Micheàl Quinn & Aphria Coffey  
Moanbaun,  
Athenry,  
Co. Galway.  
H65 N597  
19<sup>th</sup> April 2026

Re: Objection to the proposed development of an open cycle gas turbine and generator peaker plant with ancillary equipment at Pollnagroagh and Rathmorrissy, Athenry Co. Galway by the applicant Bord Gàis Energy Limited.

**Planning Reference: PC07.324113**

**AUTOTRACK FOR HGV AT ENTRANCE**  
 1:500

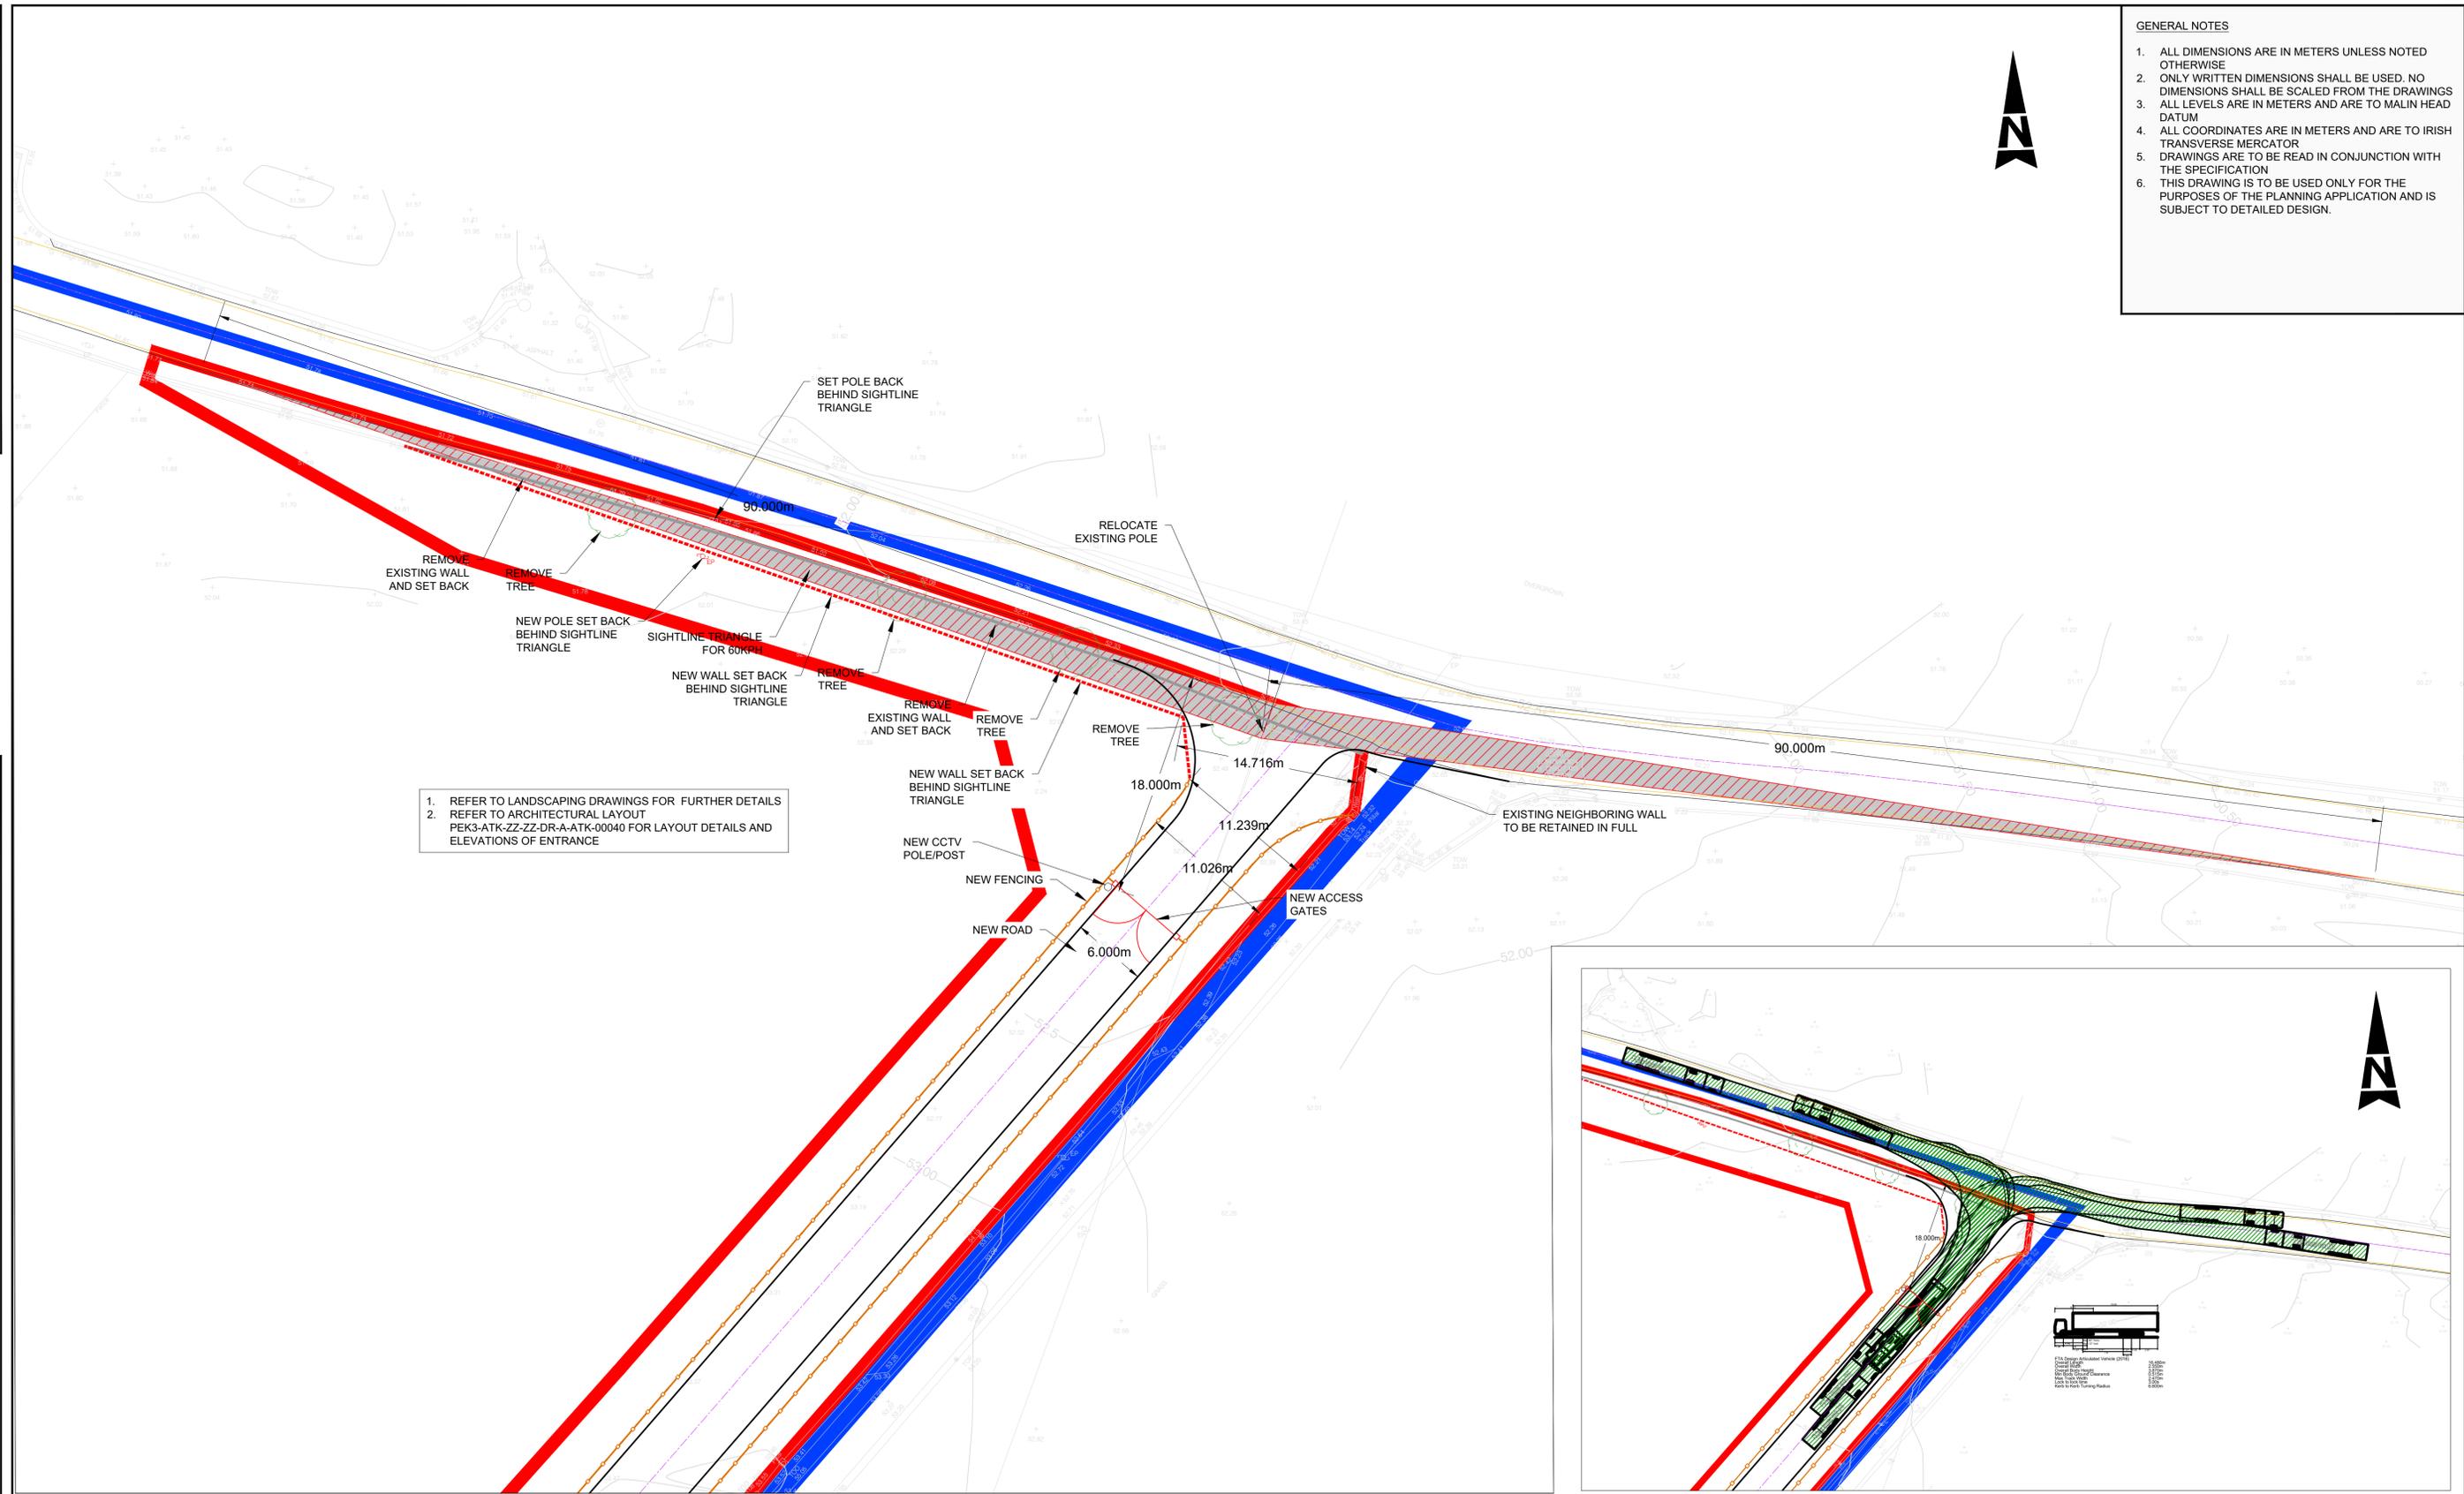
This is clearly shown in Board Gàis documentation, Drawing # PEK3-ATK-ZZ01DR-CE-901200. The 'Autotrack for HGV at Entrance' clearly shows evidence that the location of the entrance and the use of the L3103 Local Road is not suitable. [Addendum D.0](#)

We are opposed to the location of the entrance given the proximity to our residence and also the lack of clear line of sight to the entrance for traffic approaching the entrance travelling from Athenry approaching from the east (travelling West).

Heavy Goods Vehicles entering and exiting the site pose a high risk of a road collision, especially when weather conditions are poor and the sun is low in the sky during winter and spring months. Please see [Addendum D.2](#)
